Subject: FW: A/25/20/DOC Land East of New Place Nursery, Arundel Road, Angmering

I have had a further discussion with WSCC regarding the proposed connection. They are willing to accept the restricted discharge on the proviso of the following (see enclosed plans) in order to ensure the receiving system is in good working order;

Please find revised drainage layout attached showing the revised tank position to accommodate the RPZ and porous drive areas. An additional revision will follow shortly indicating all RWP's and round plot drainage and details however the main objective at this stage is to secure approval with WSCC on a connection into their system.

Consulting Civil Engineers				
CLIENT GD GROUP				
ARCHITECT CITYZEN				
JOB TITLE ARUNDEL ROAD ANGMERING				
DRAWING TITLE CONSTRUCTION DETAILS SHEET 2 OF 2				
DRAWN LH	ENGINEER CS	CHECKED CS	APPROVED	
DATE NOVEMBER 2019		SCALE @ A1	1:20	
JOB NO. C1276	STATUS P	DRAWING NO.	301	REV P1

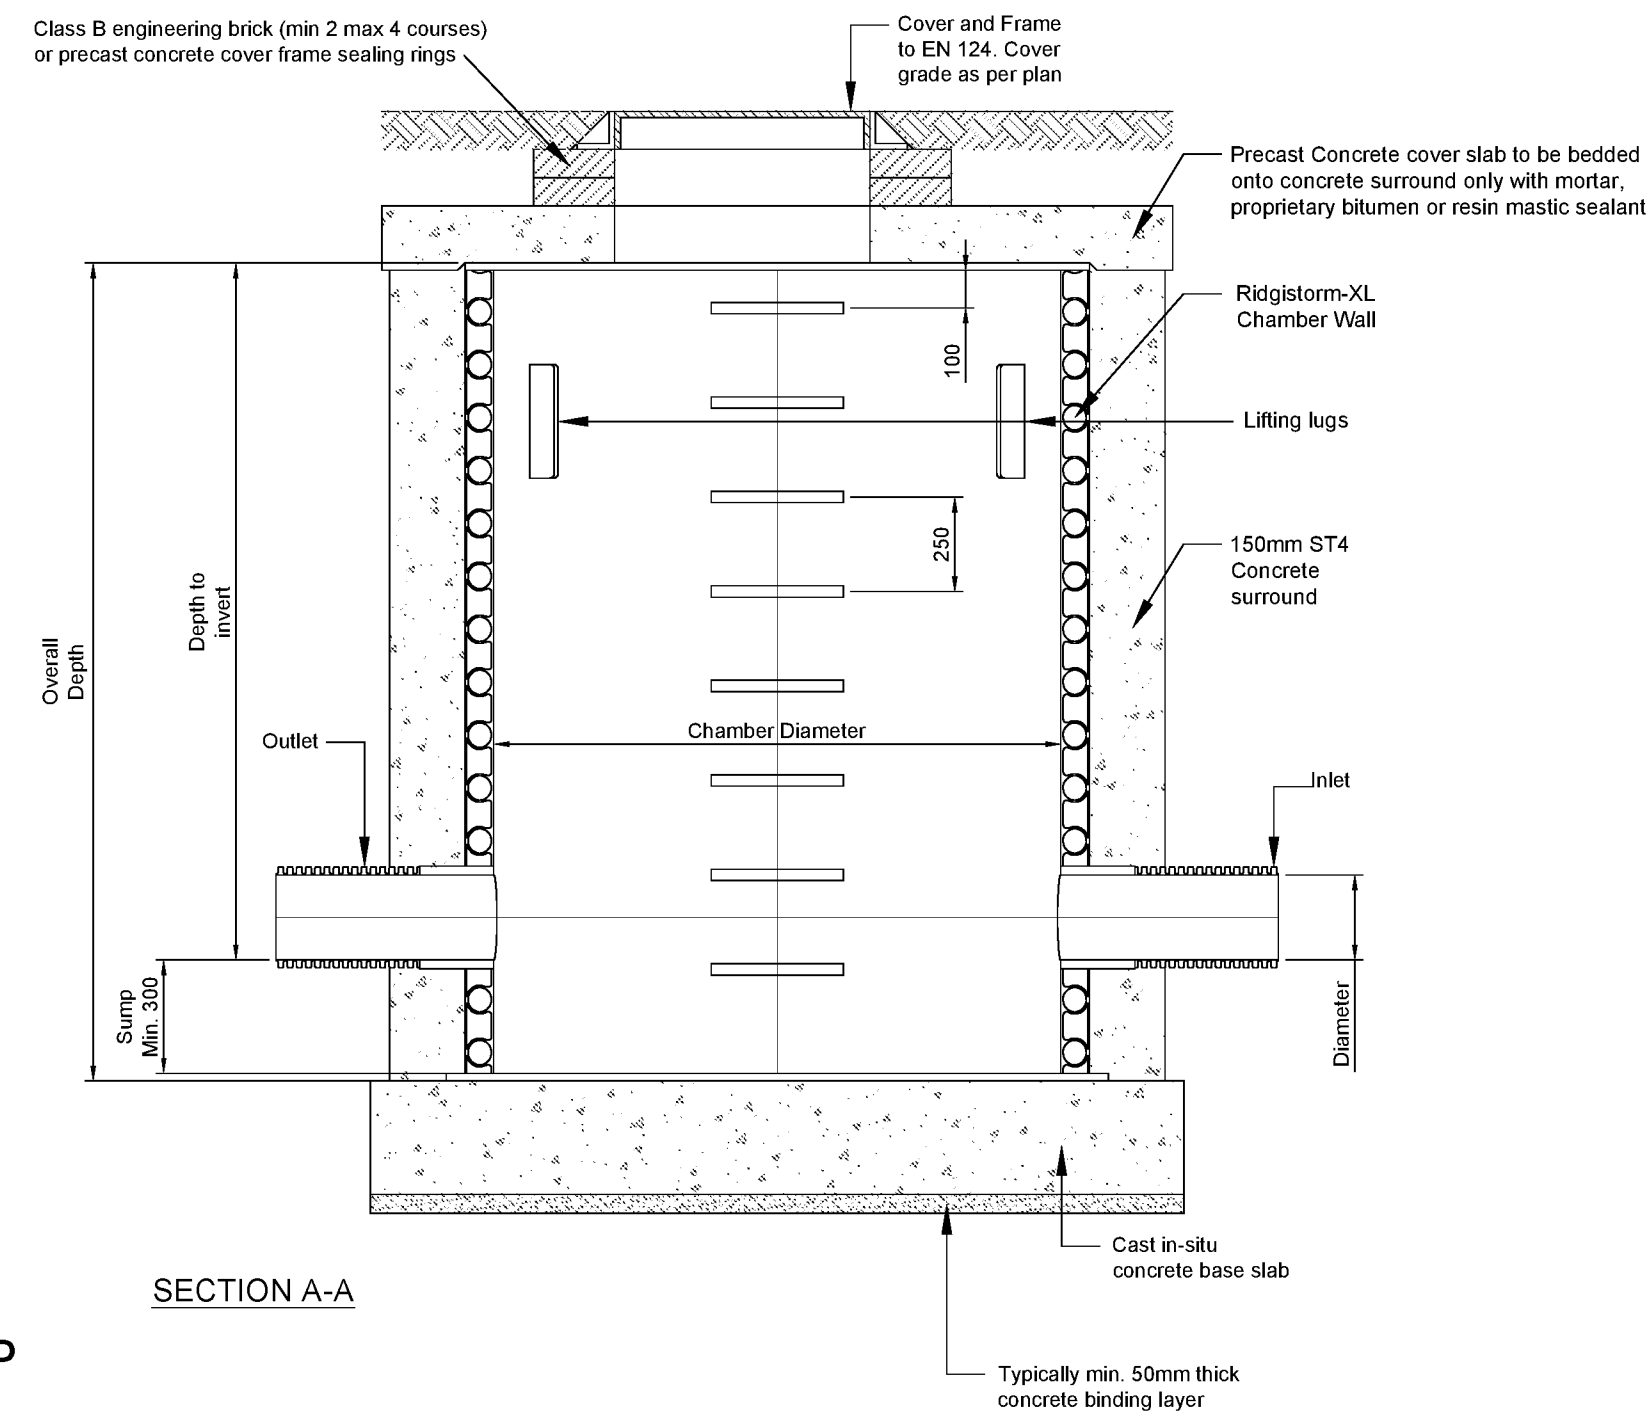
We have spoken to our tree officer regarding the location of the potential storage tank. The tank appears to encroach into the tree root protection zone and would not be permitted. It also needs to take account of the expansion of this zone as the trees reach maturity. I would suggest that you seek further advice from the developers arboriculturalist. Ultimately, the proposals will need also be agreed by our own tree officer.

Please note that the development will need to include permeable paving for water treatment ie. property driveways.
